Department of Transportation

Region 2 Permits

October 25, 2024

RE: Waterbury Filing No. 1
Final Plat (SF237)

POND 3
SCALE: 1"=30'

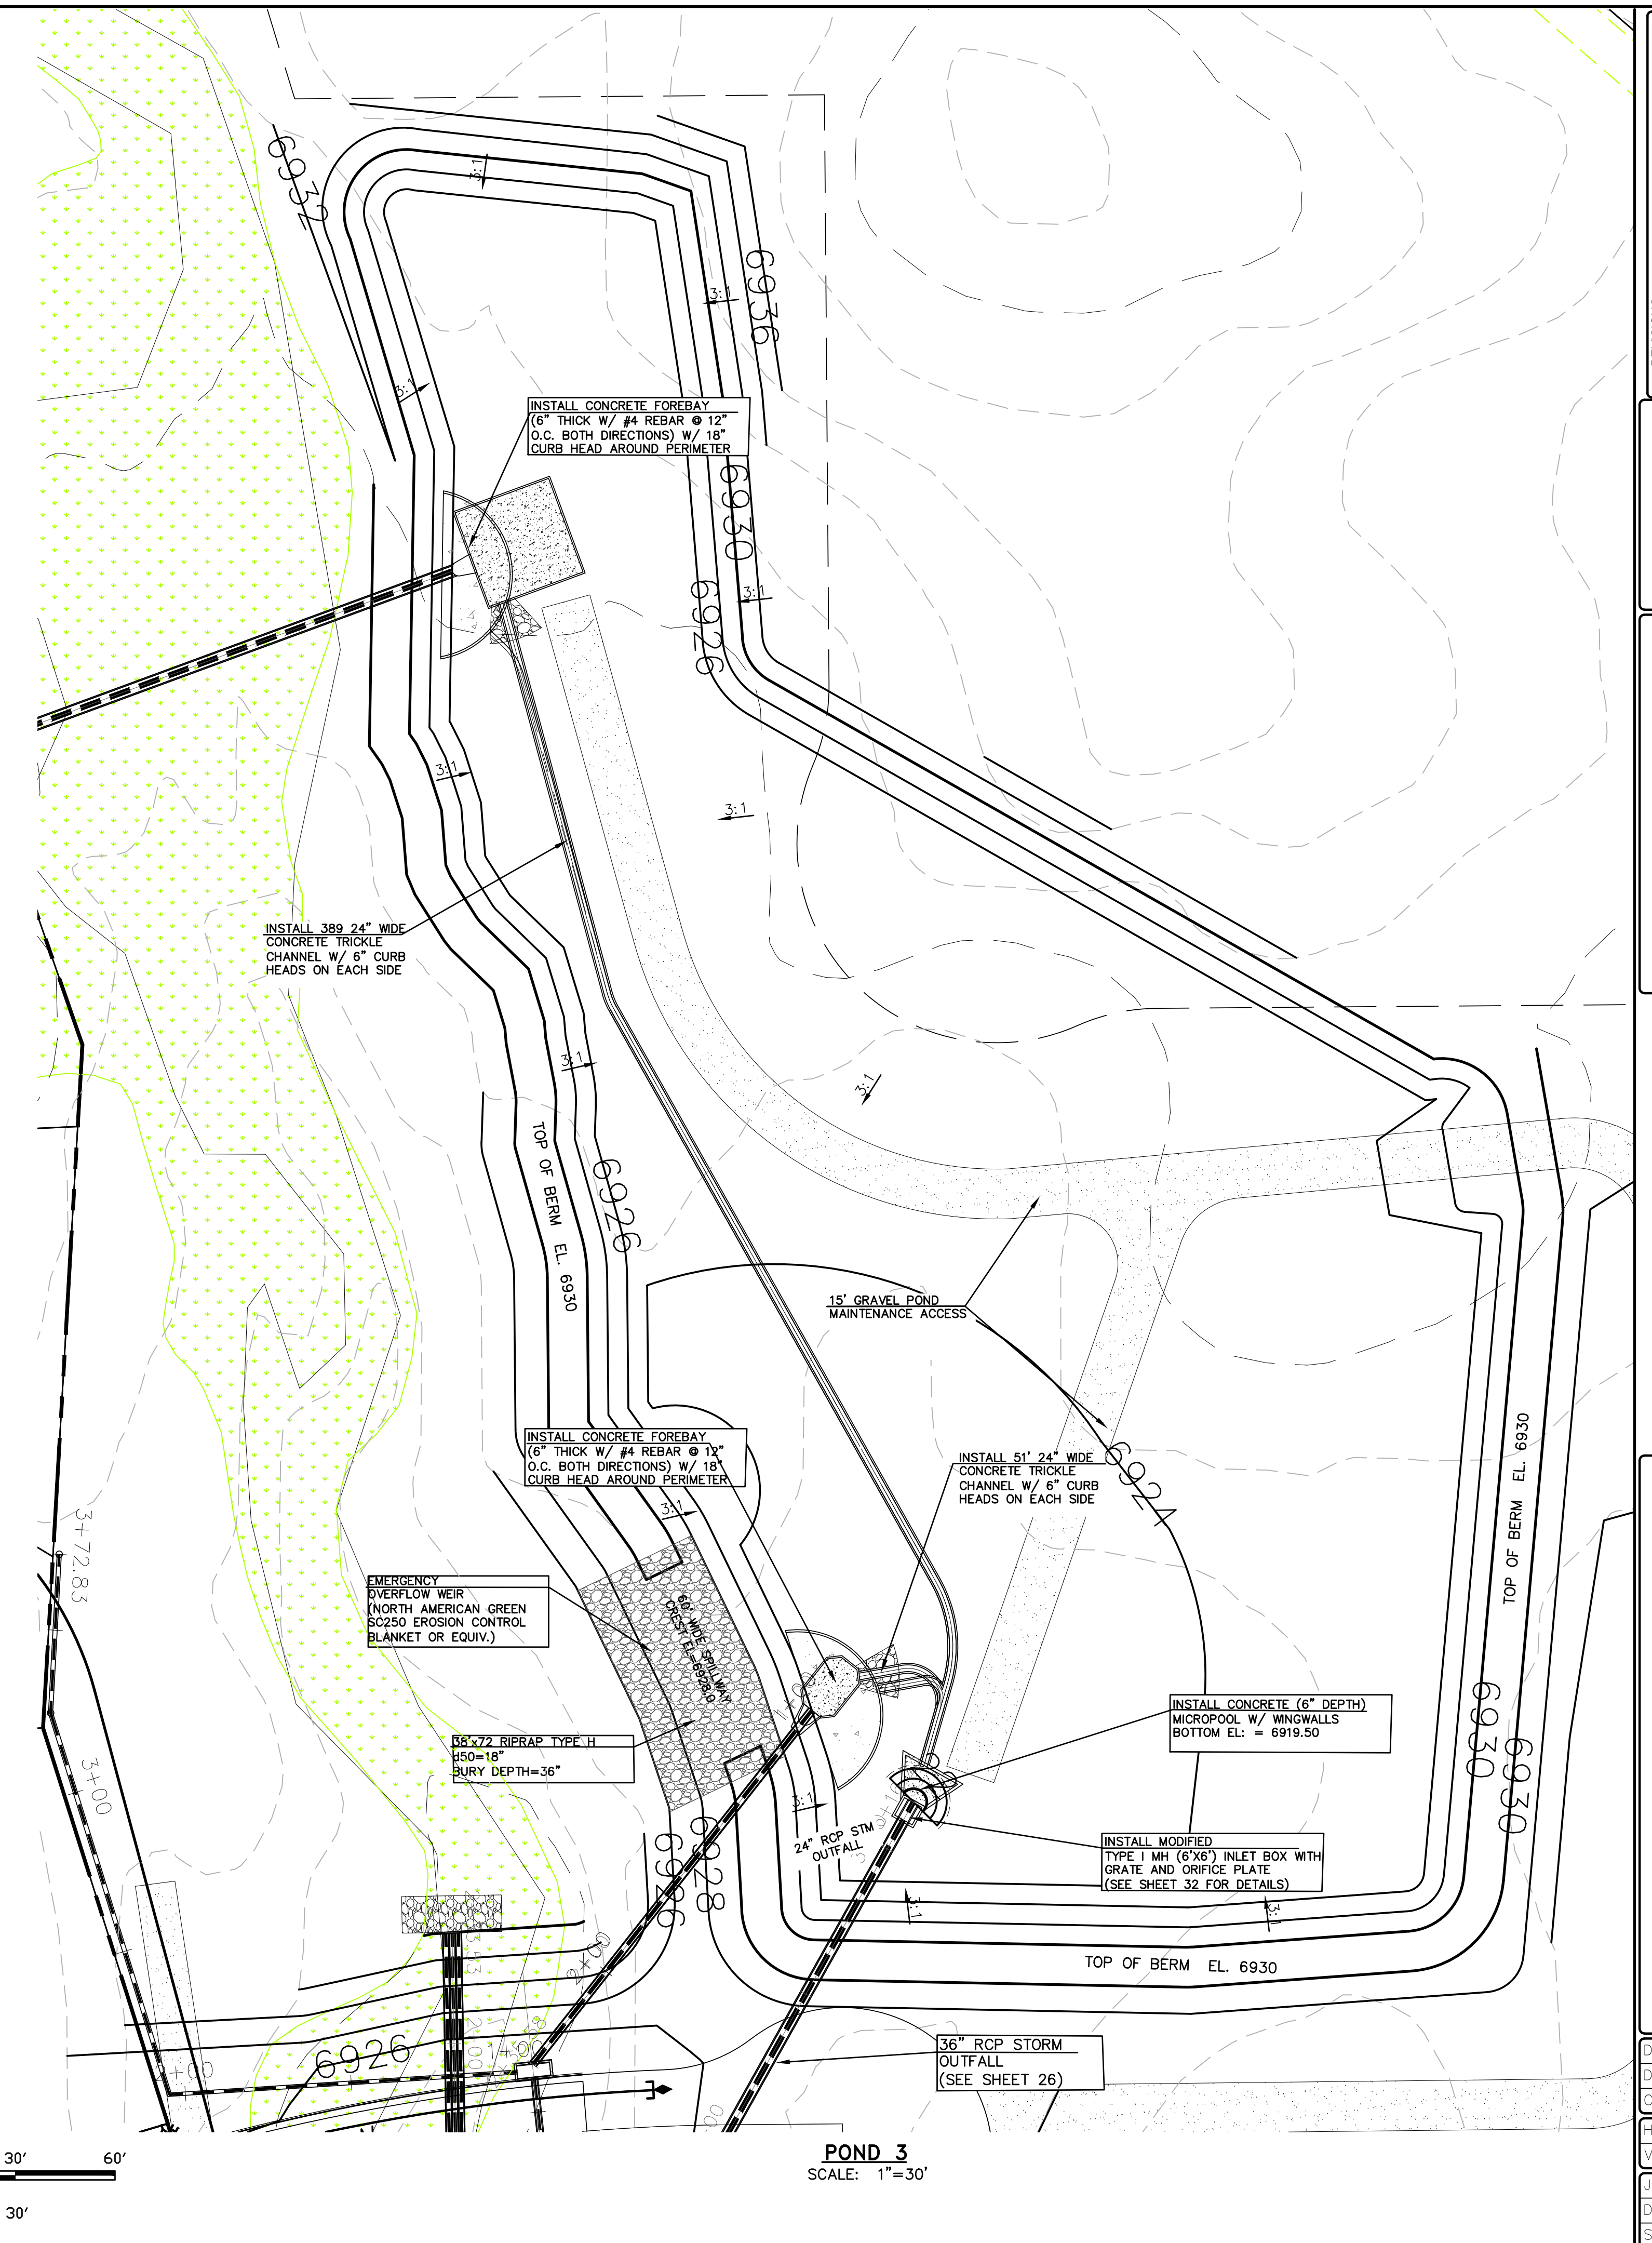
- Sheet No. 48 - the spillway for Pond 3 is shown to have 3:1 side slopes and 1 foot of freeboard. The drainage report (pdf p. 237) shows the spillway as having 4:1 side slopes.
 - Revise the plan or report to provide consistency.
